LAND TECHNOLOGIES, INC.

Response to SEPA Comments

Dell's Nursery/ 104th Rezone - Notice of SEPA PA22041

Above: Wetland and stream mapping on and near the site.

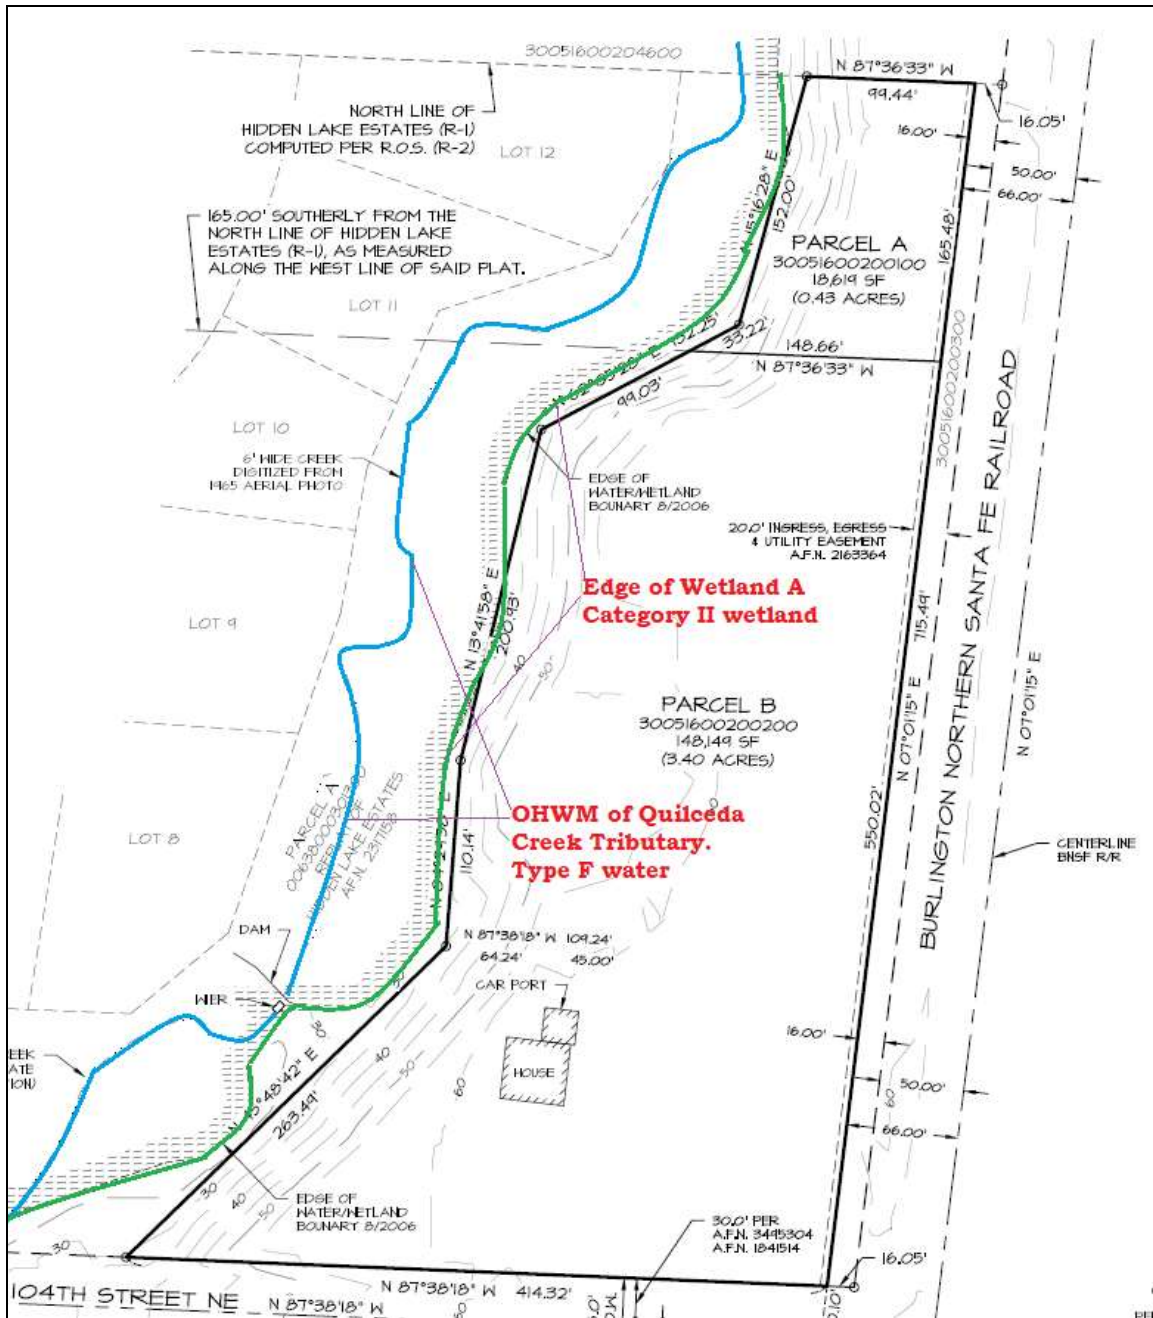
It would be great if the maps provided could depict the pond feature. I'm having trouble visualizing how close the reduction in buffer is to the impounded area of water that is considered part of the wetland. I'm imaging the amount of water in this pond-like feature (very obvious on arial imagery) increases in the wet season, causing concern for flooding if the buffer is reduced close to this feature.

When were the wetland boundaries surveyed? The information provided made this unclear. The ponded area could be much bigger if these measurements are taken from the 2006 survey...

We do show the edges of the wetland boundary along this property and CA features that might have an impact on the use of this property. The "pond" is offsite and not a feature relevant to the use of this project.

This was a question also asked by Doug Gresham from DOE and the Biologist gave detailed response. In Short Ed Sewall's response was "the Critical Areas were flagged originally September 10^{th,} 2018. The Site was revisited August 13, 2020 confirming there were not changes to CAs from the 2018 flags. All flags were in place and verified as appropriately placed.

Sheet L-3

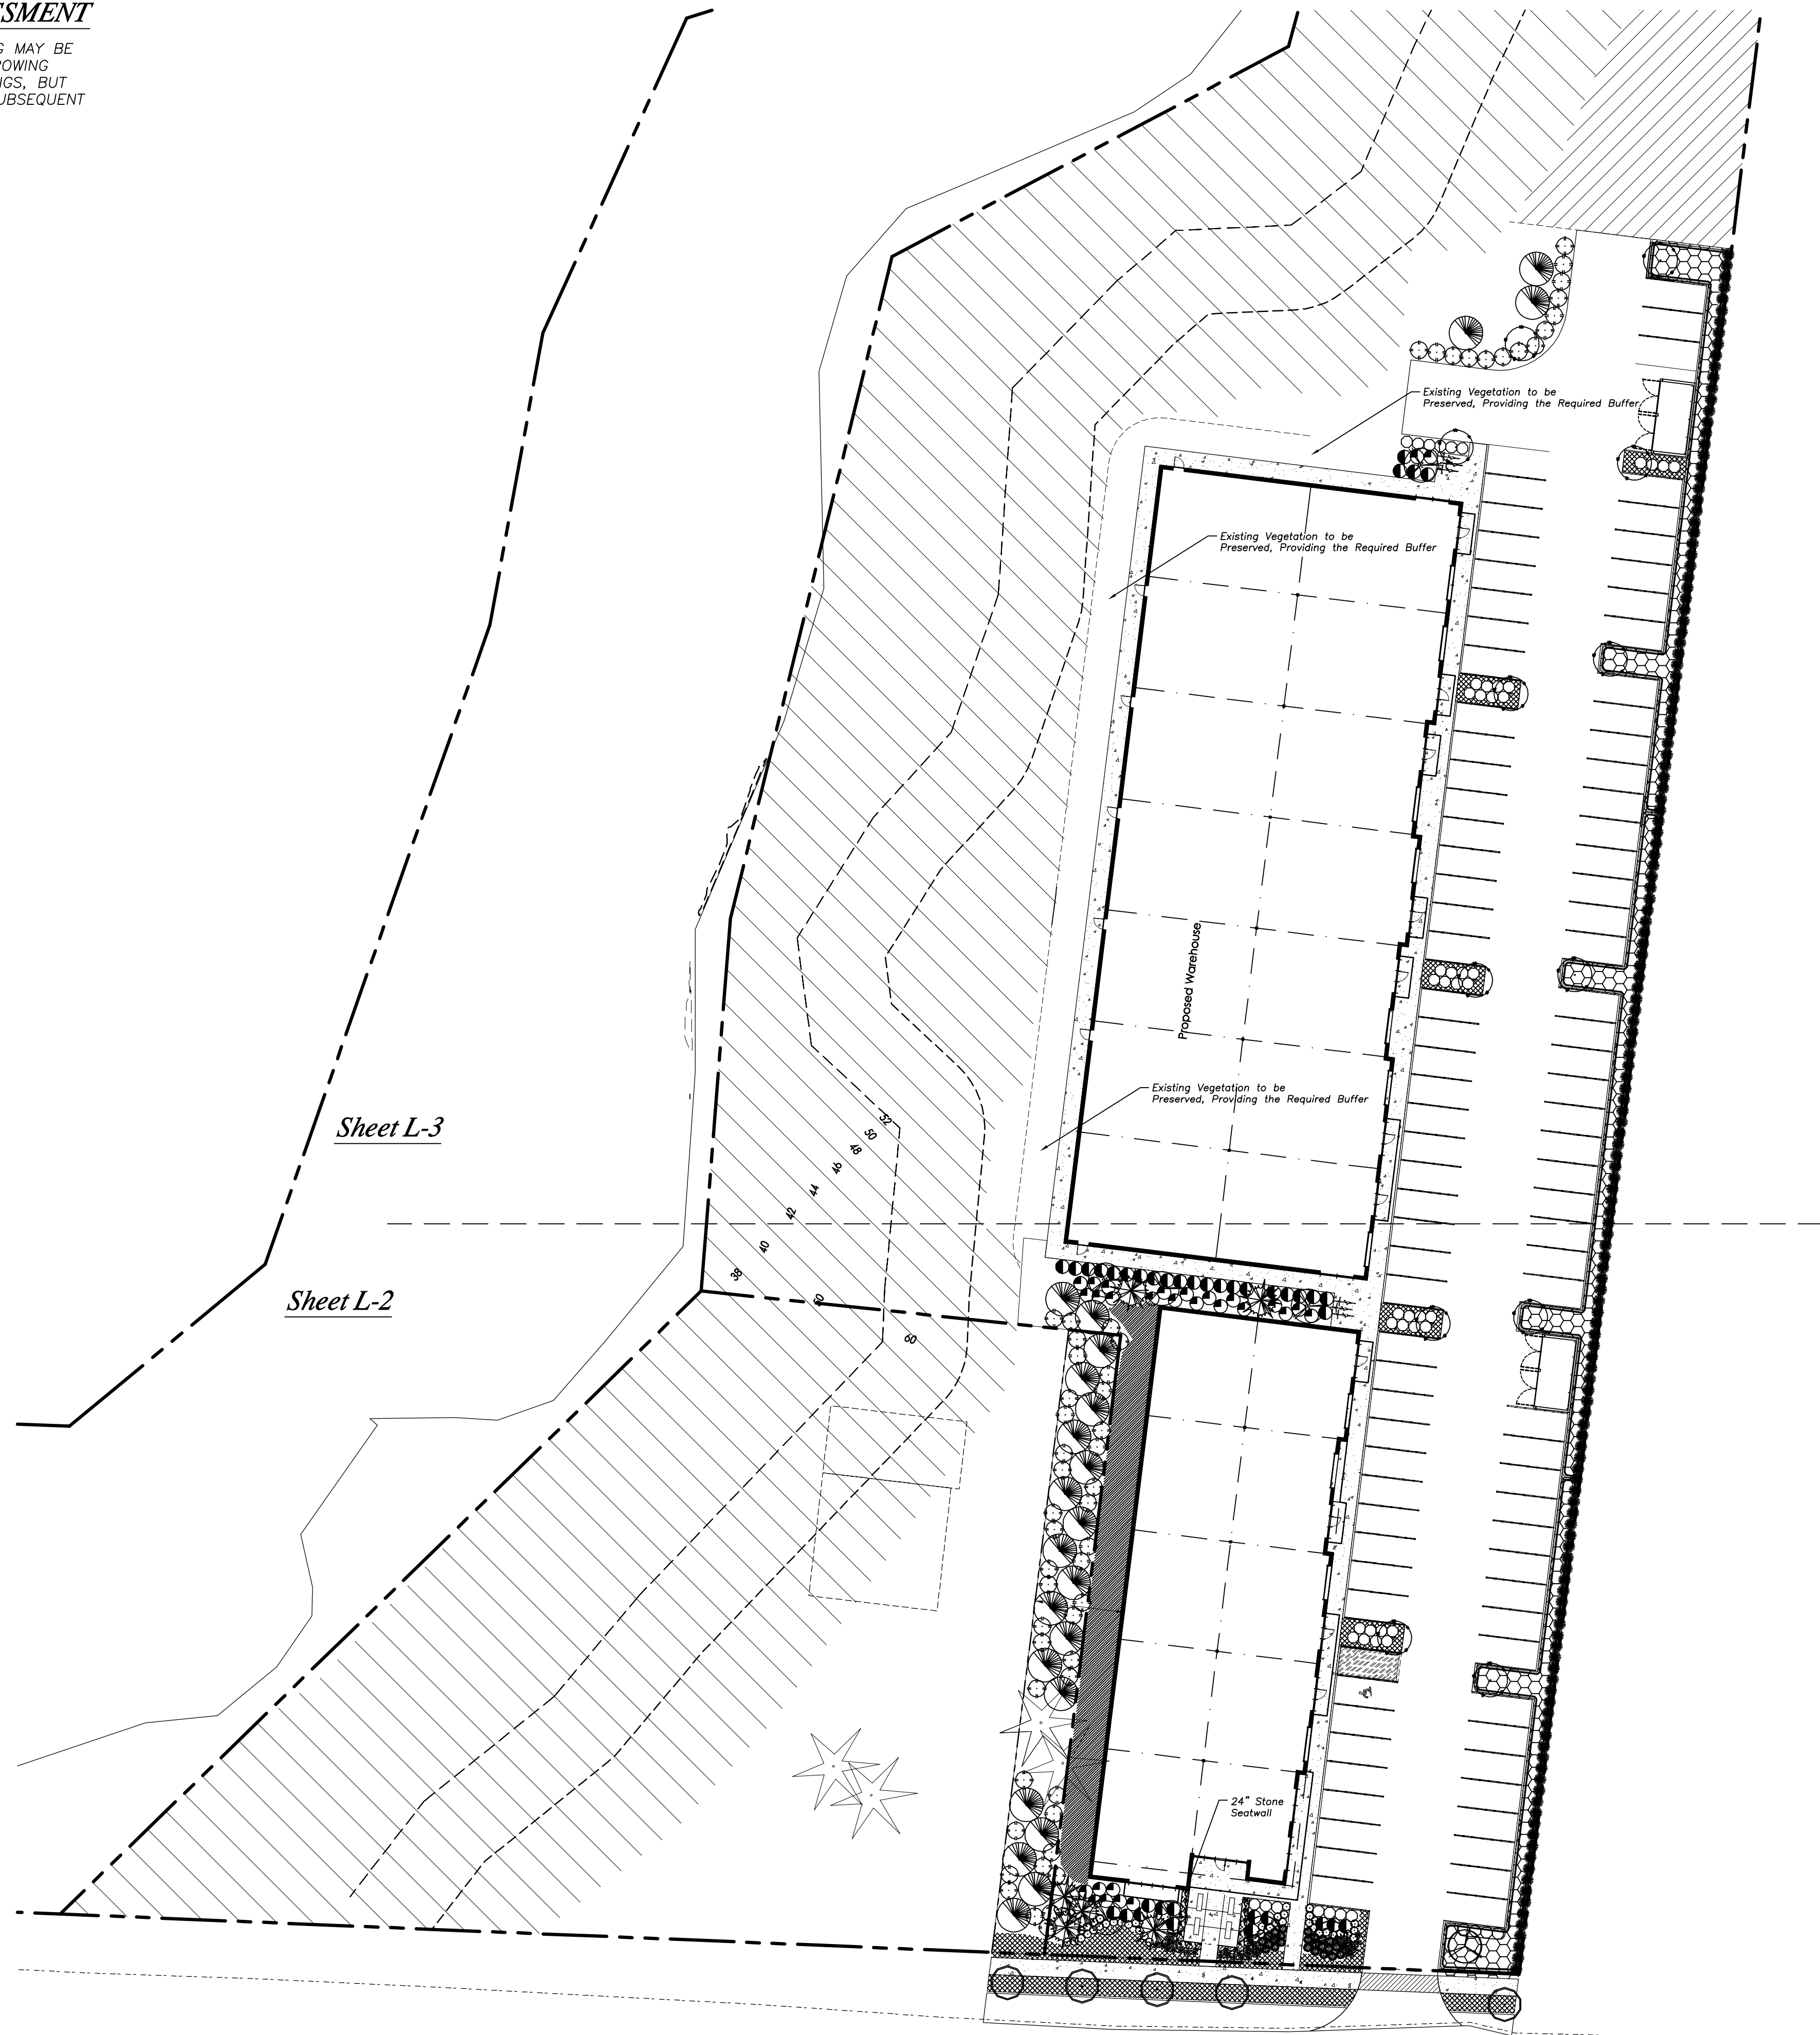
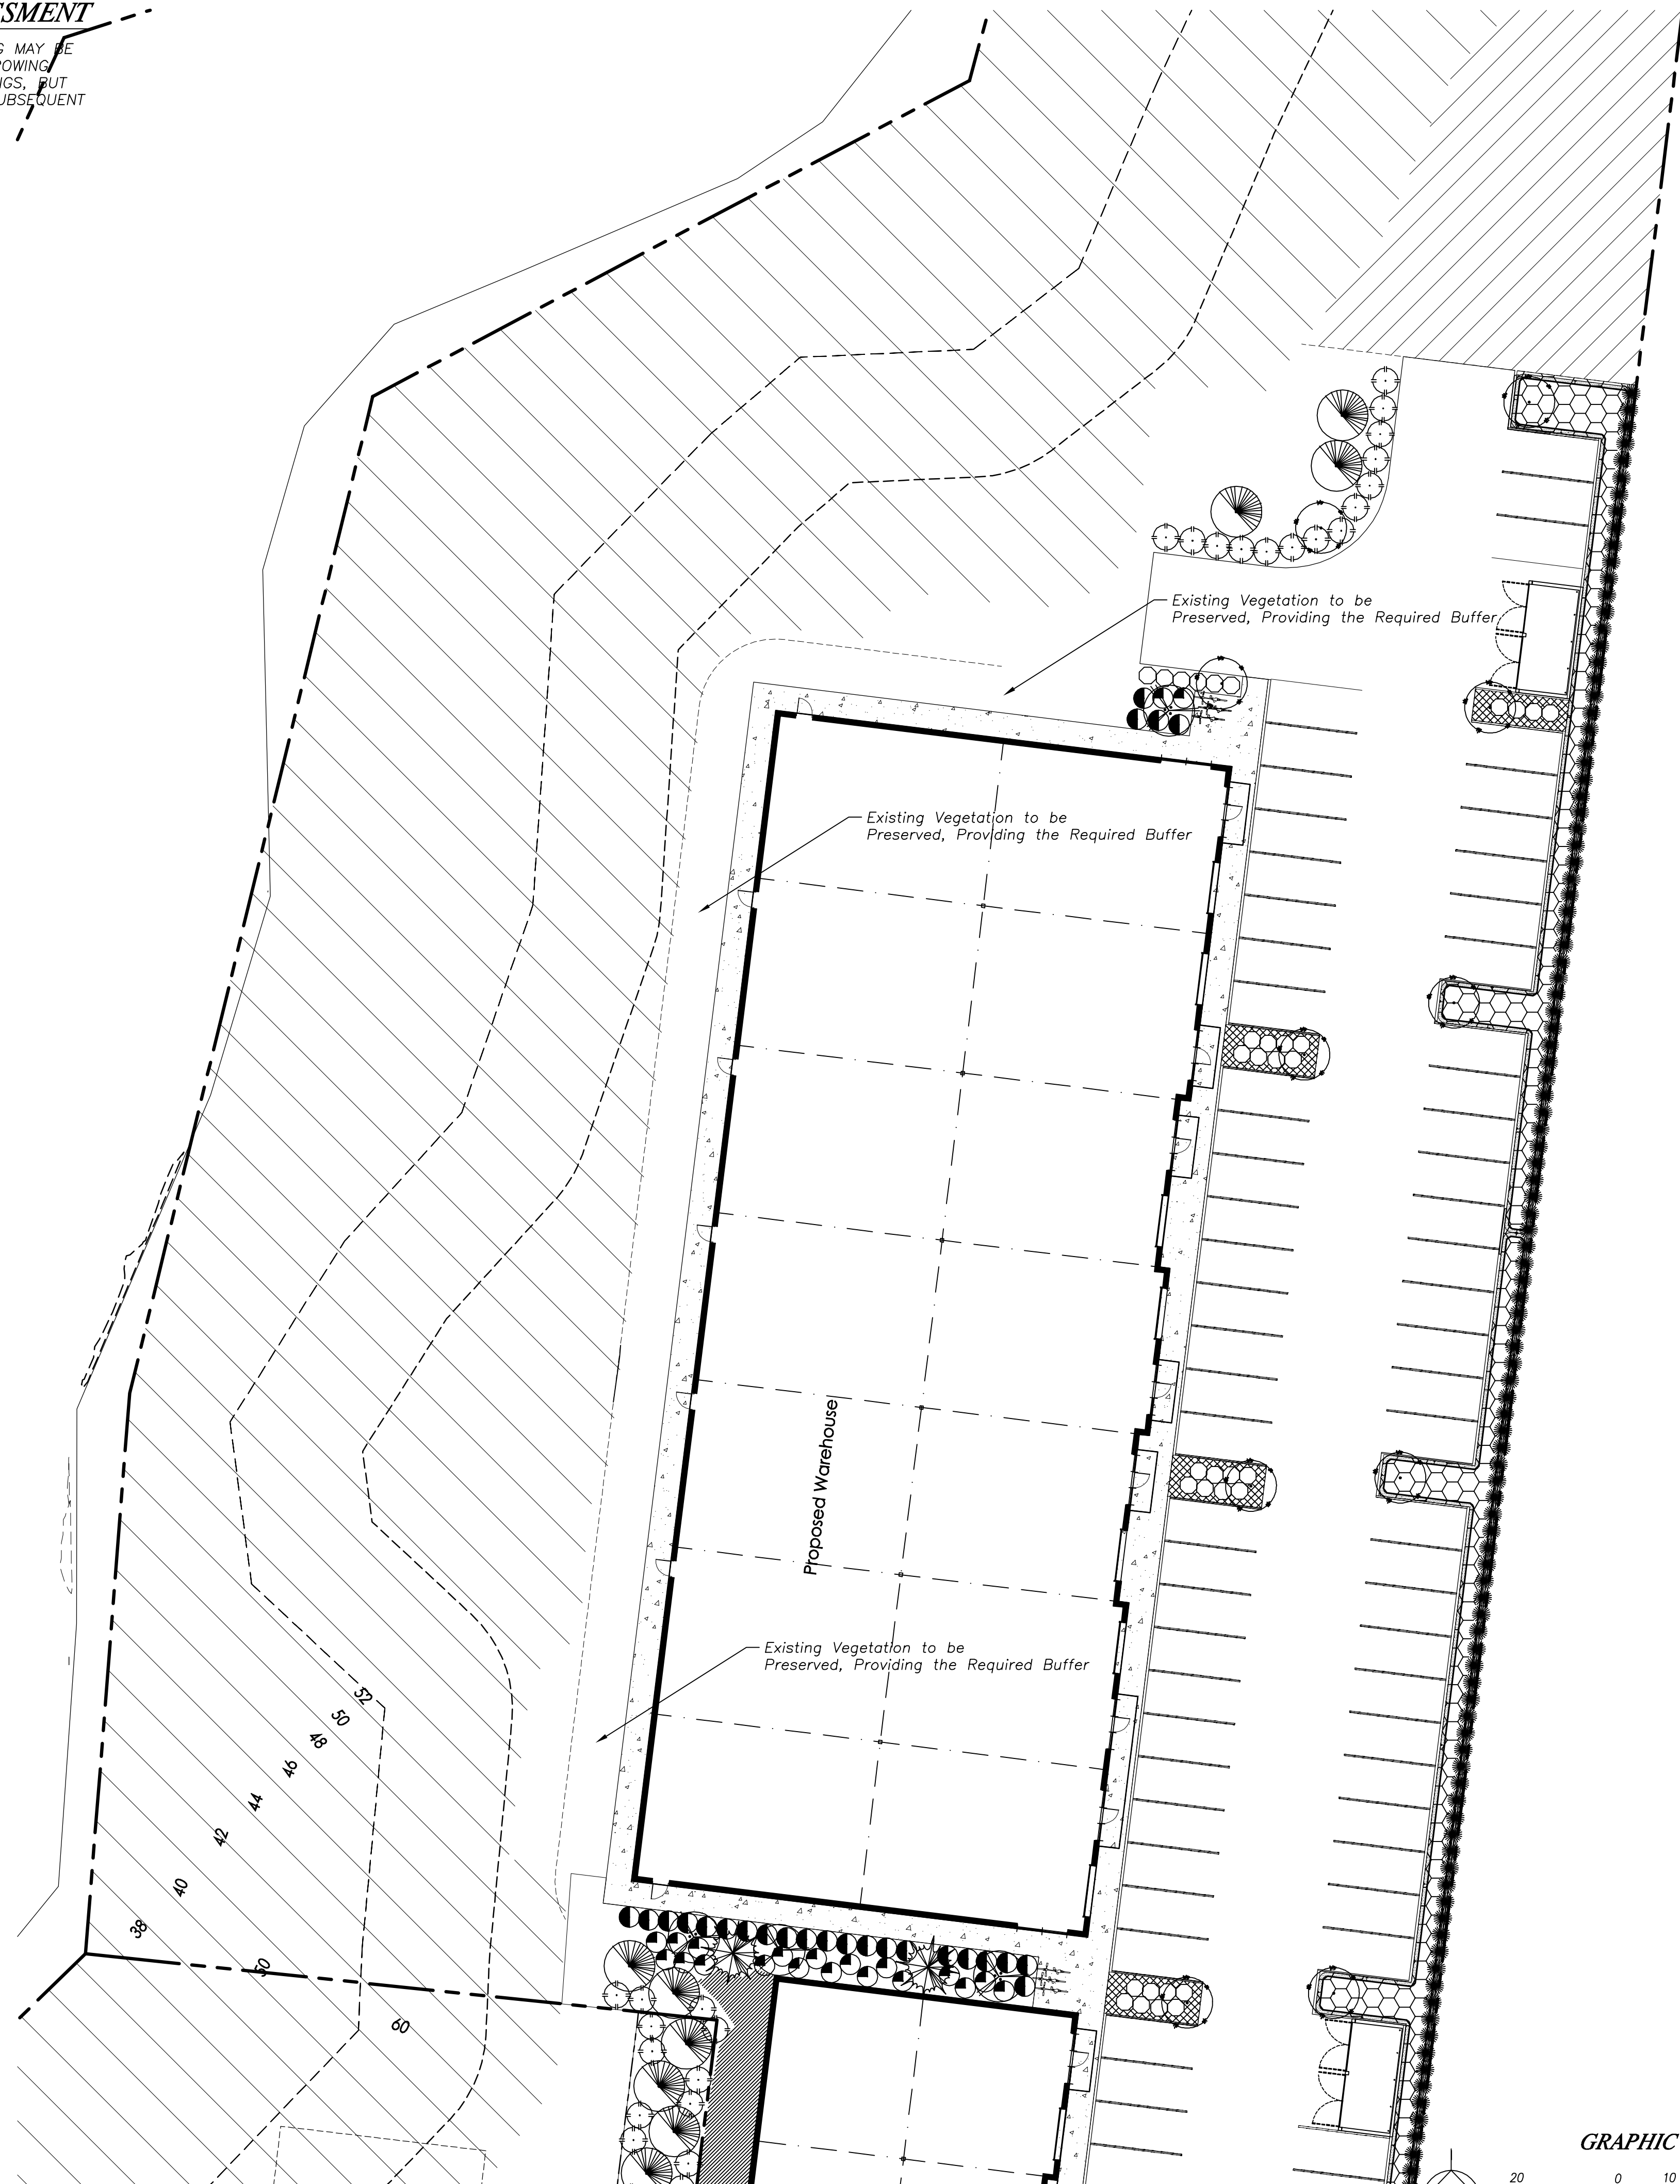
On the landscape plan, the applicant does not seem to include their plans for the 'wetland buffer addition'. A clear plan outlining how this area will be restored and monitored is needed.

Detailed Mitigation plans with details plantings will be submitted with the Civil Construction Plans.
